Our ref: SSD-21184278

Subject: Woodlawn Advanced Energy Recovery Centre – Request for Information in Submissions Report

Woodlawn Advanced Energy Recovery Centre
Department's Request for Information

Title: SITE PLAN

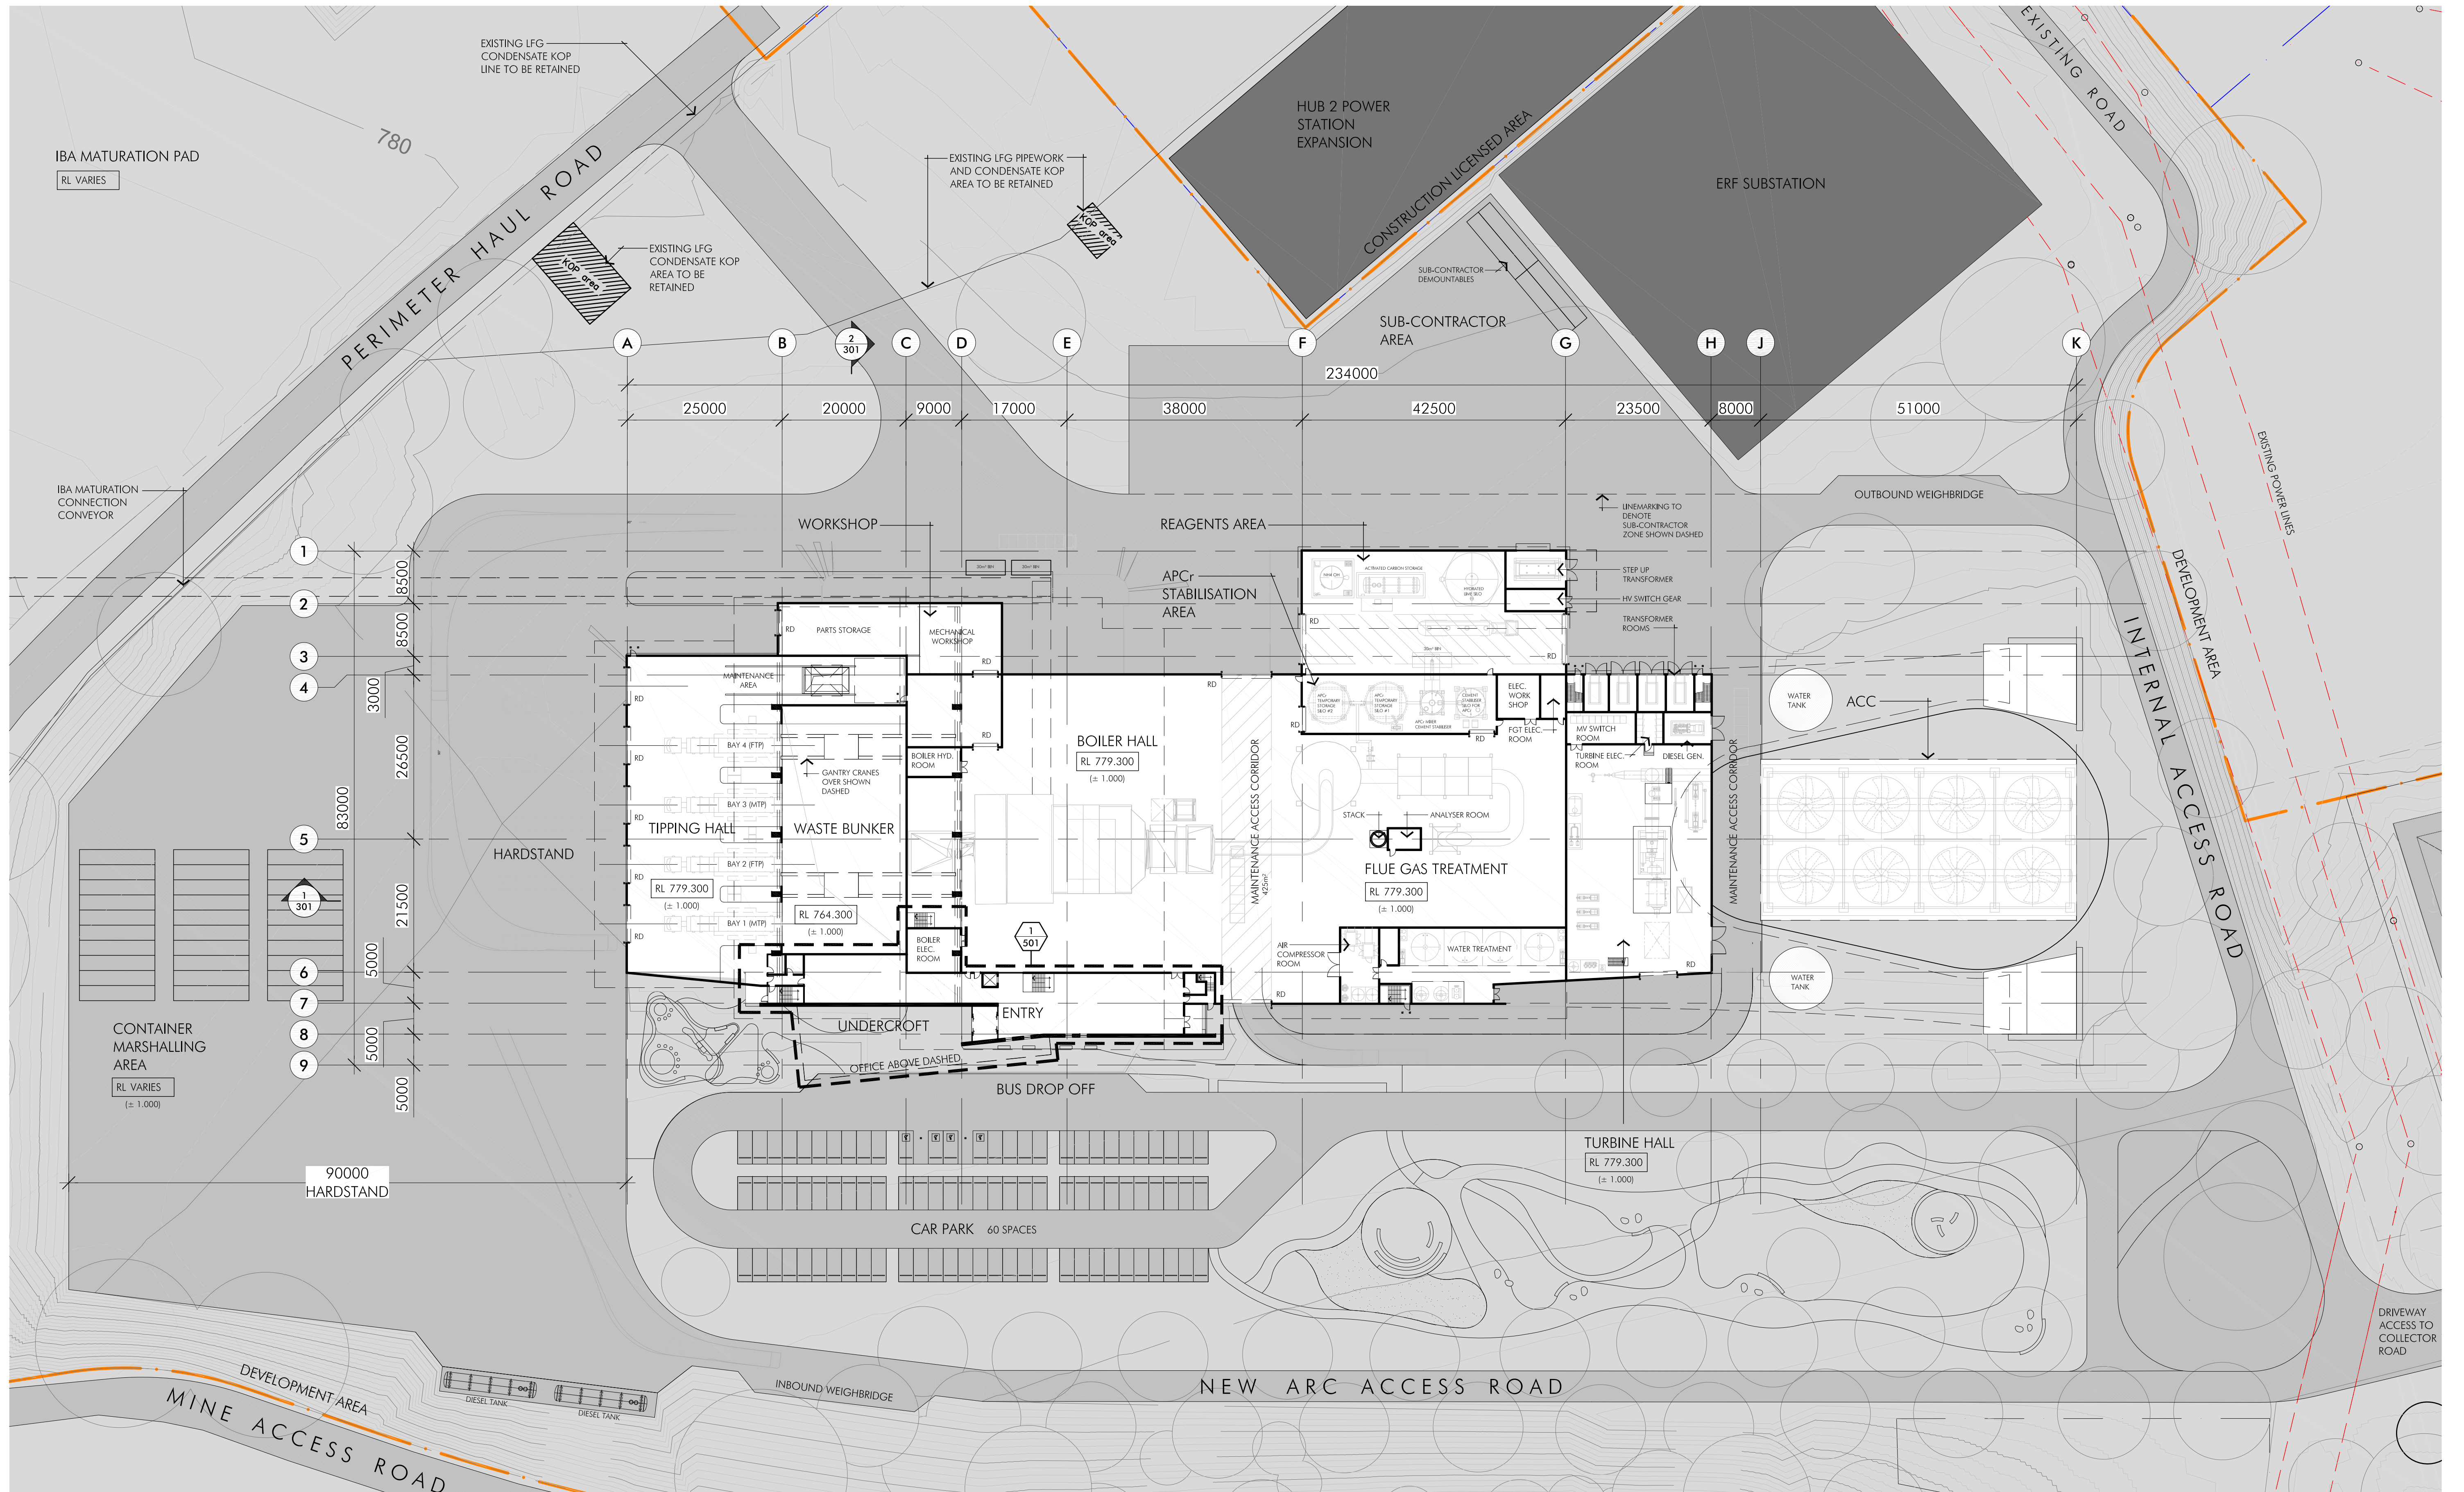
The site plan in Figure 4.3 of the EIS does not show where the stack will be located.

Recommendation: Site plans should be updated to clearly show the location of the stack.
